# GRADING AND EROSION CONTROL PLANS

## THE COMMONS AT FALCON FIELD

### SECTION 7, TOWNSHIP 13 SOUTH, RANGE 64 WEST OF THE 6TH P.M. PEYTON, EL PASO COUNTY, COLORADO

ISSUE	DATE
INITIAL ISSUE	3/16/23
RESUBMITTAL	6/28/23

GRADING AND  
EROSION CONTROL  
COVER SHEET

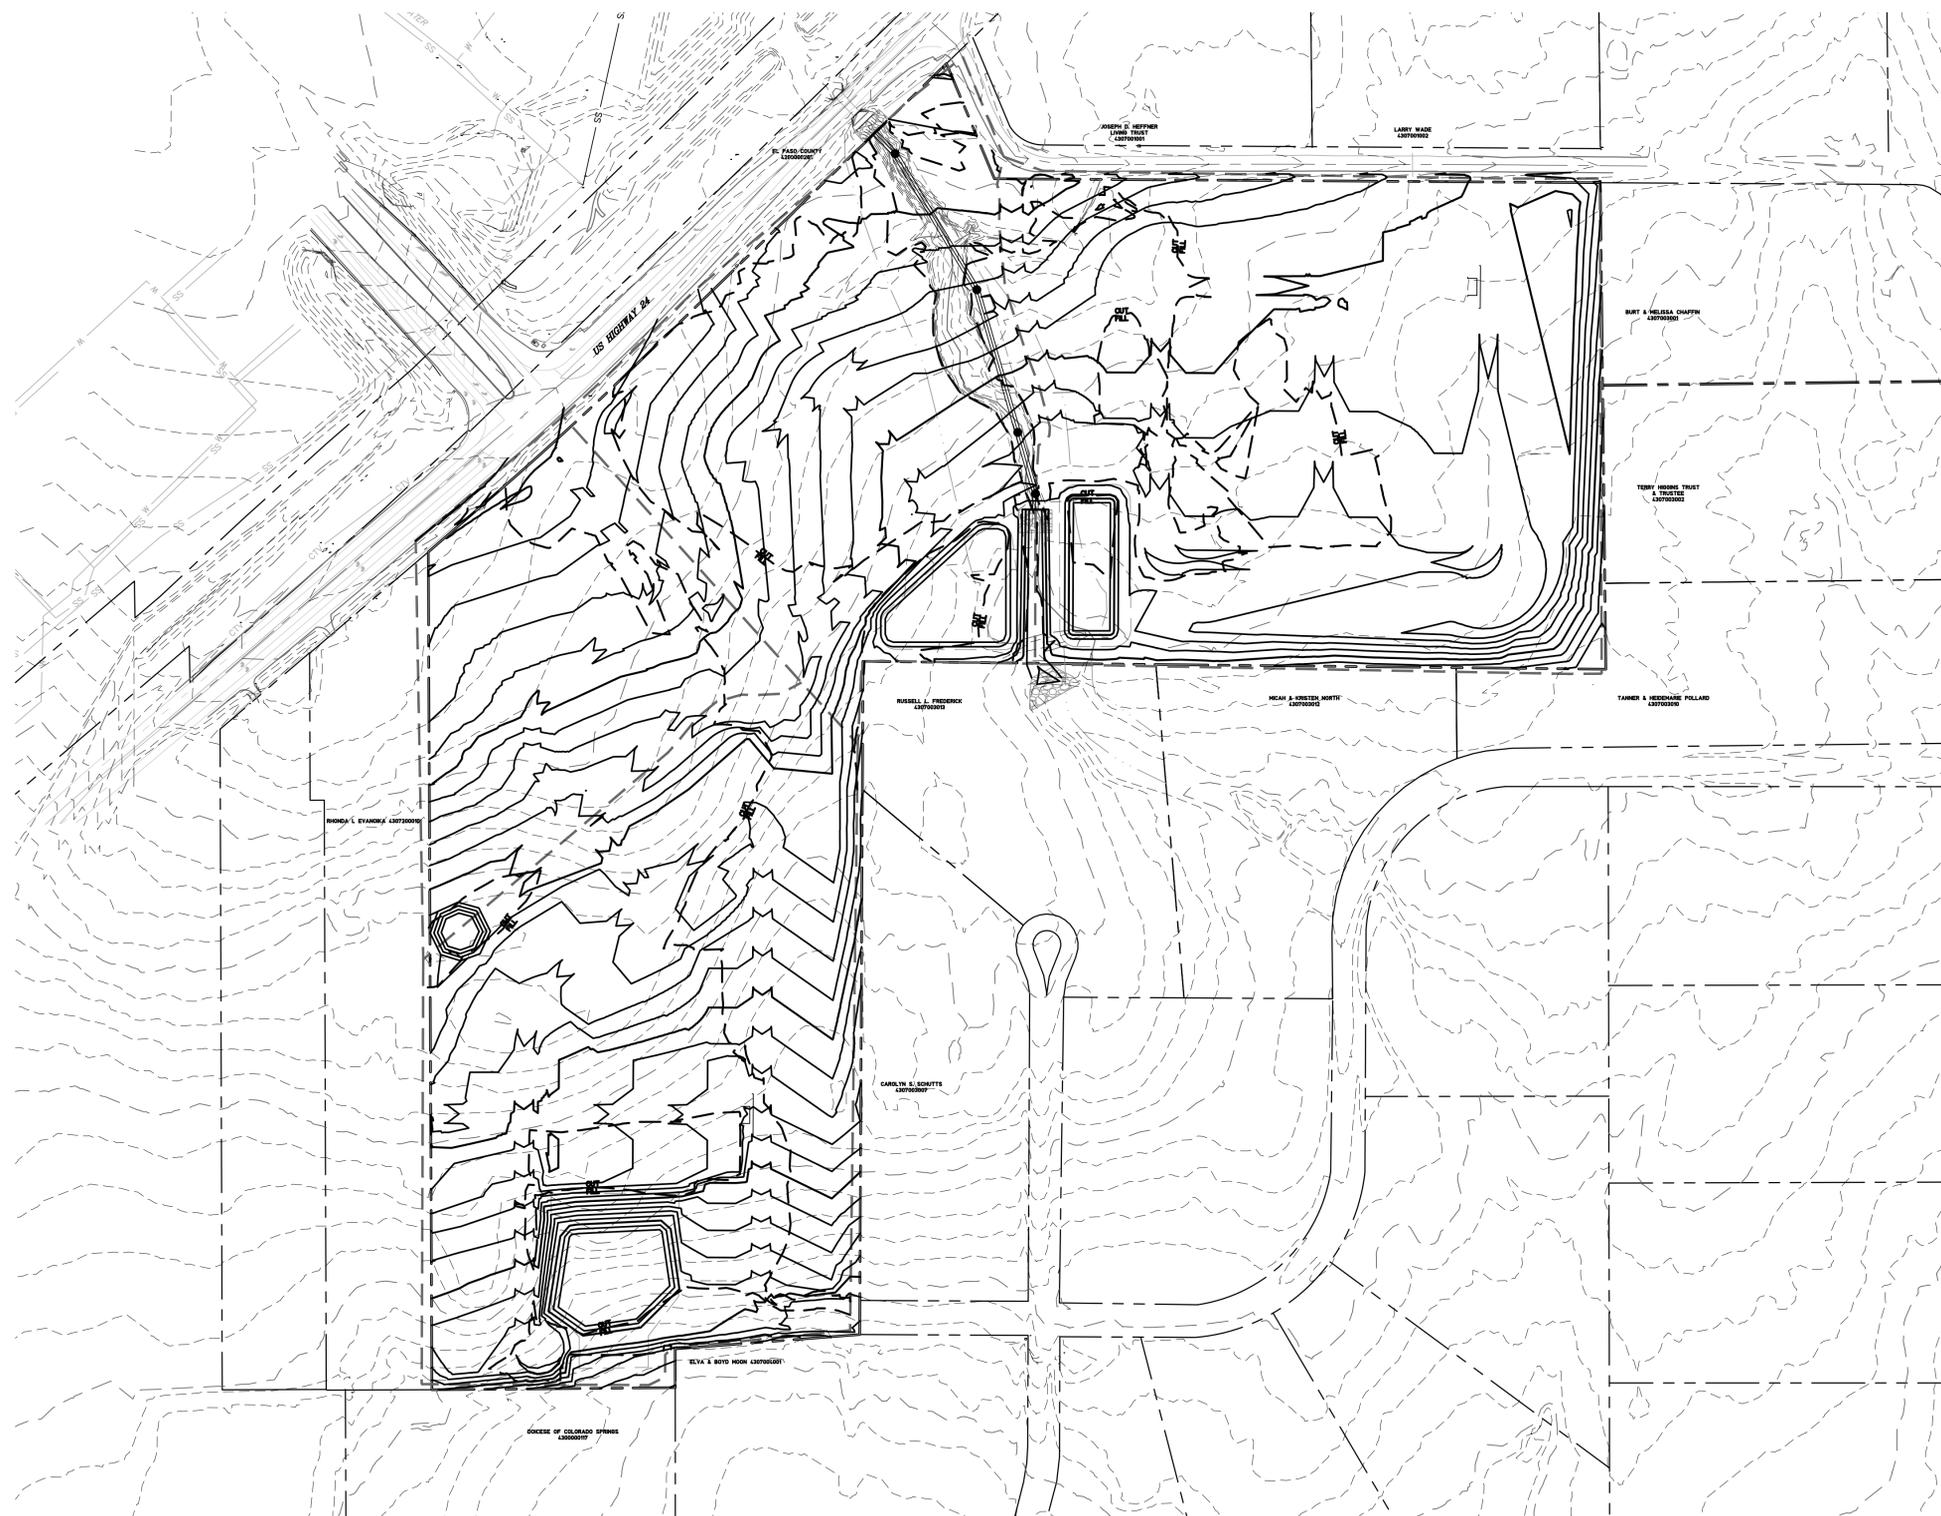
Because early grading is being requested, these GEC Plans should reflect the proposed early grading condition, not the final condition. The GEC Plans should show all utilities and grading that is going to be constructed under early grading.

Please submit a pre-development grading and erosion control plan (overlot grading, rough cut of roadways etc.) for review. Pre-development grading shall not include curb/gutter, sidewalk, storm pipes, inlets etc. Submit an FAE form for the pre-development grading proposed. If grading within the floodplain is proposed with the pre-development grading request, full analysis/design and CD's are required of the floodplain/channel along with the appropriate floodplain development permits, no-rise letter, etc. Also, the drainage report shall provide discussion/analysis of this pre-development grading condition.

Repeat of Note 16 - replace with the checklist note 17.
